CITY OF ALBUQUERQUE

October 23, 2006

**Re: Santa Fe 3 (new) at the Trails Unit II (Tract 4) Grading and Drainage Plan
Engineer's Stamp dated 10-13-06 (C9/D1D)**

CITY OF ALBUQUERQUE PUBLIC WORKS DEPARTMENT ENGINEERING GROUP			
SANTA FE 3 AT THE TRAILS UNIT II GRADING & DRAINAGE PLAN			
Design Review Committee	City Engineer Approval	Last Design Update	Mo./Day/Yr.
City Project No. 730087	Zone Map No. C-9-Z	Sheet 3	Of 3

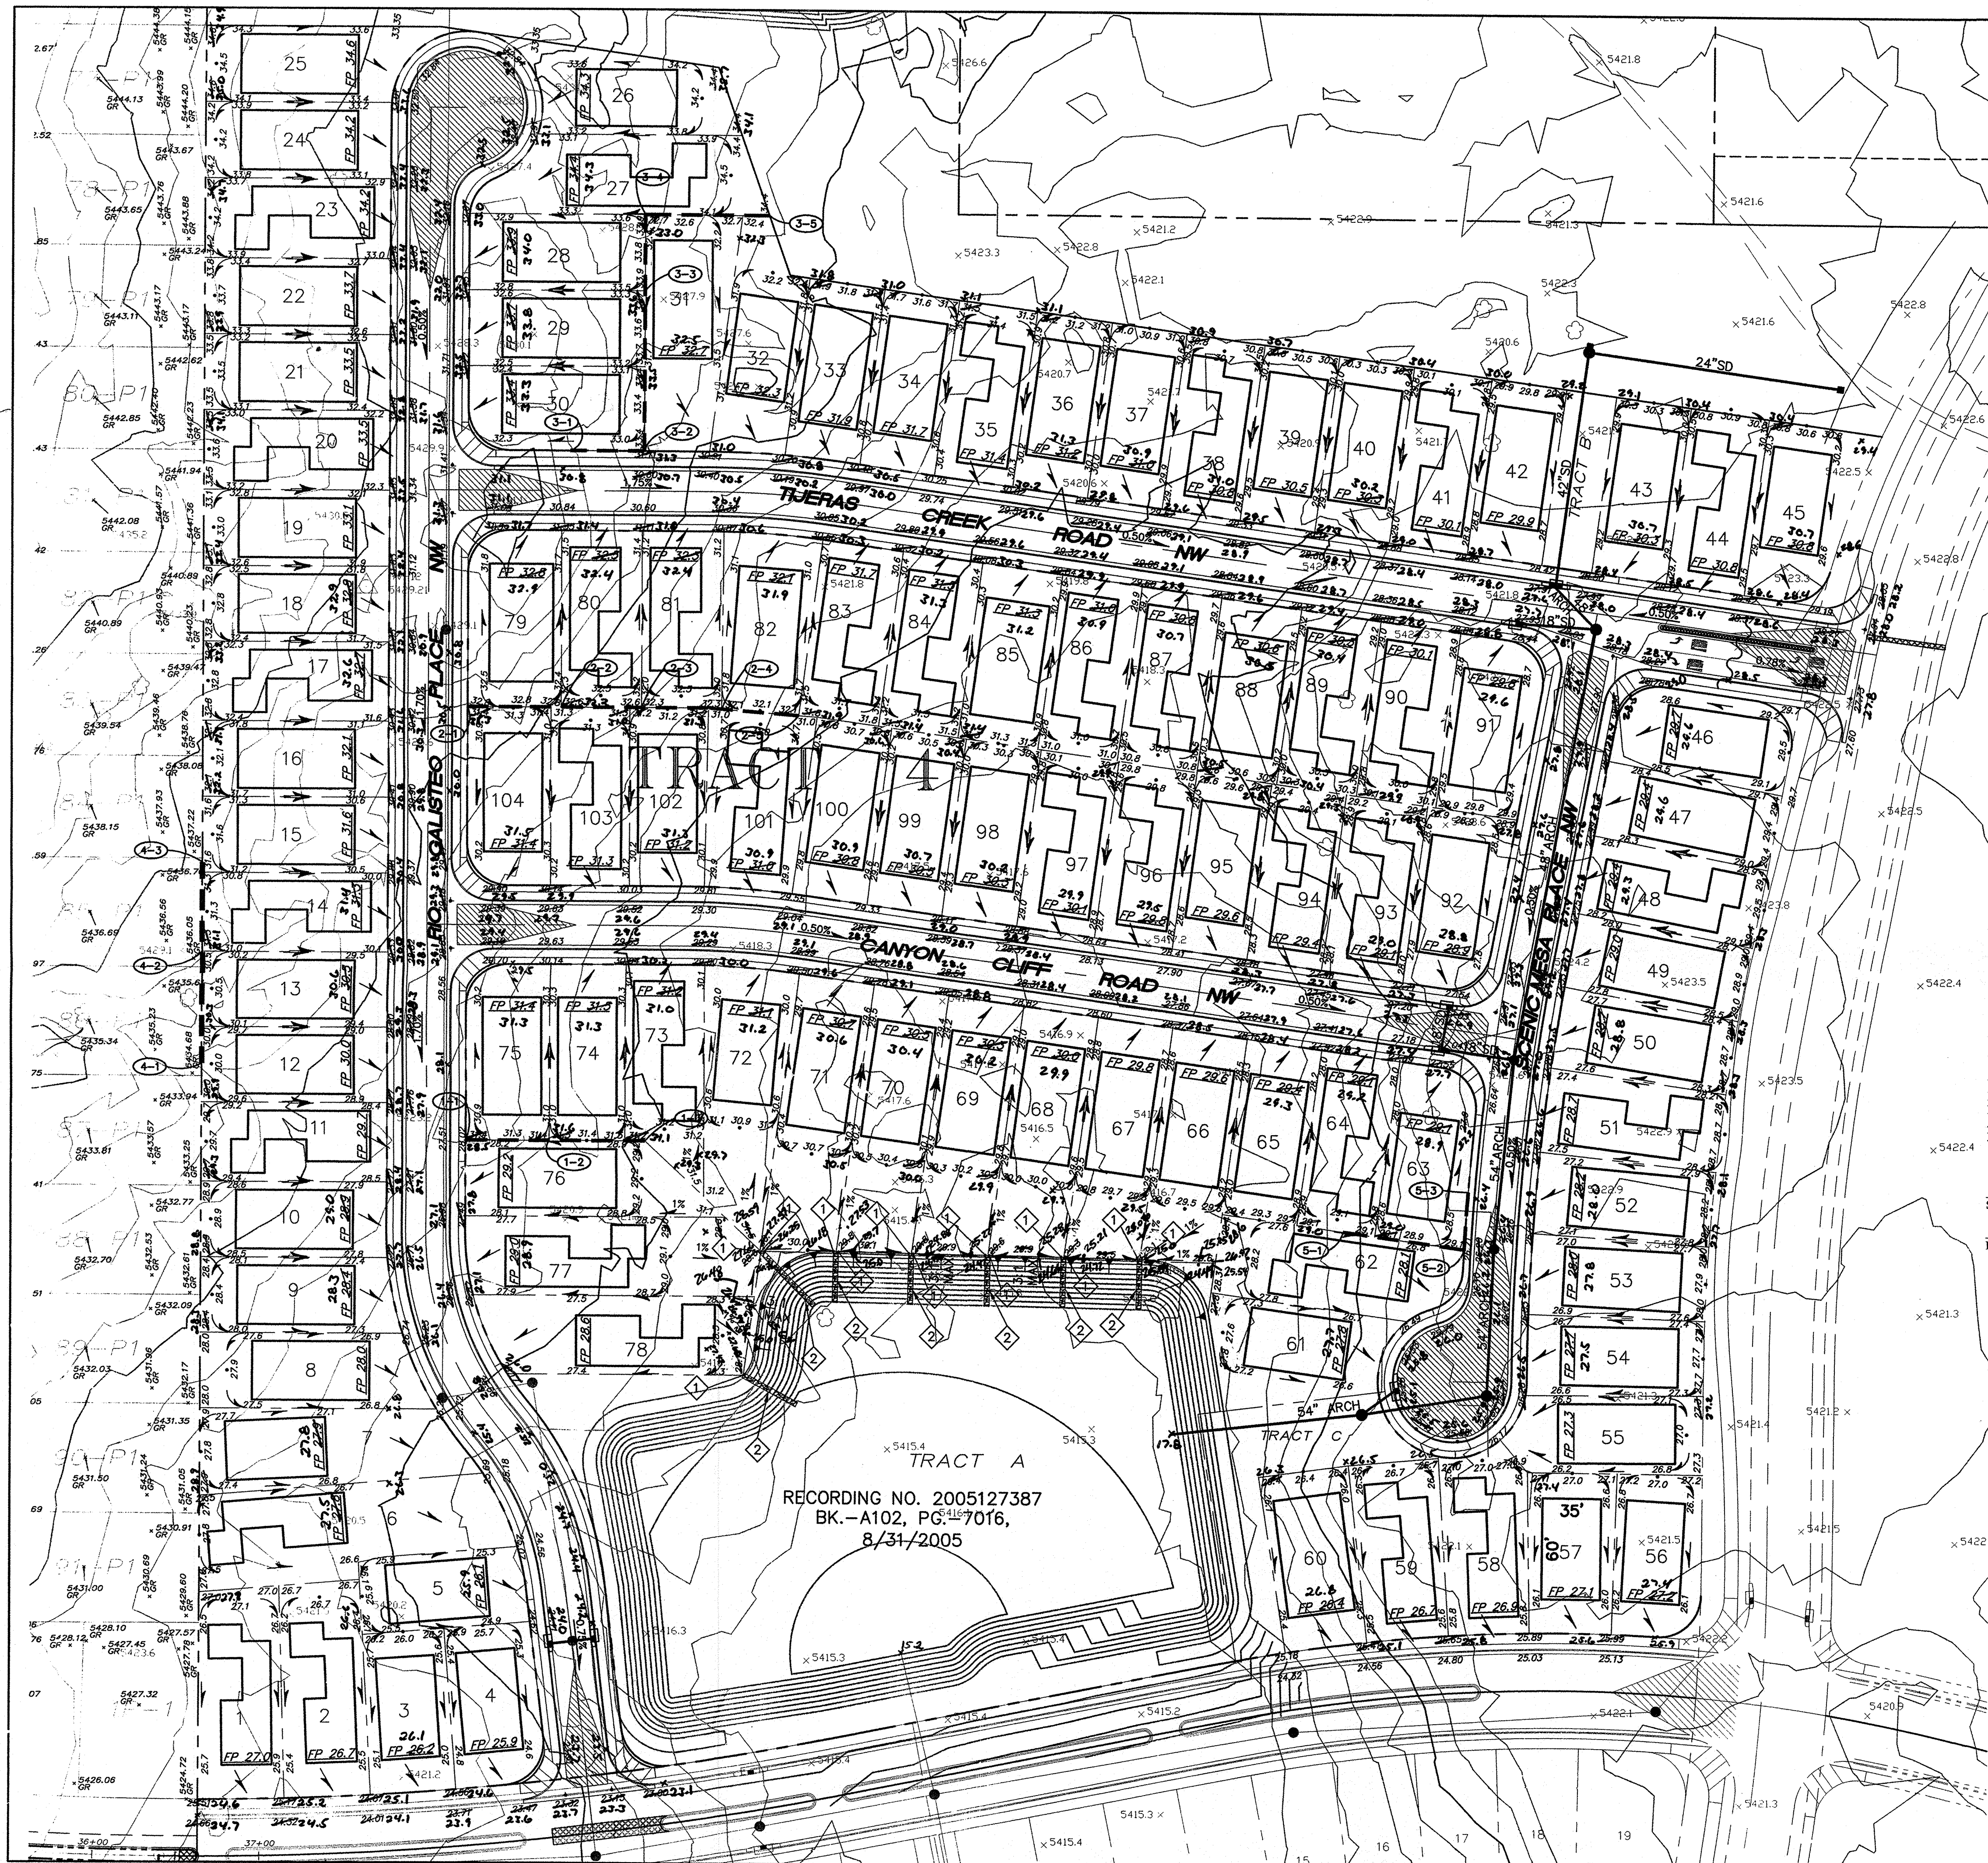
This submittal has more dwelling units per acre than the previous submittal for this project, which increases the amount of impervious area and therefore the runoff. Provide the calculations for the increase in runoff and whether pond F/system is still adequate. Also, provide street capacity calculations.
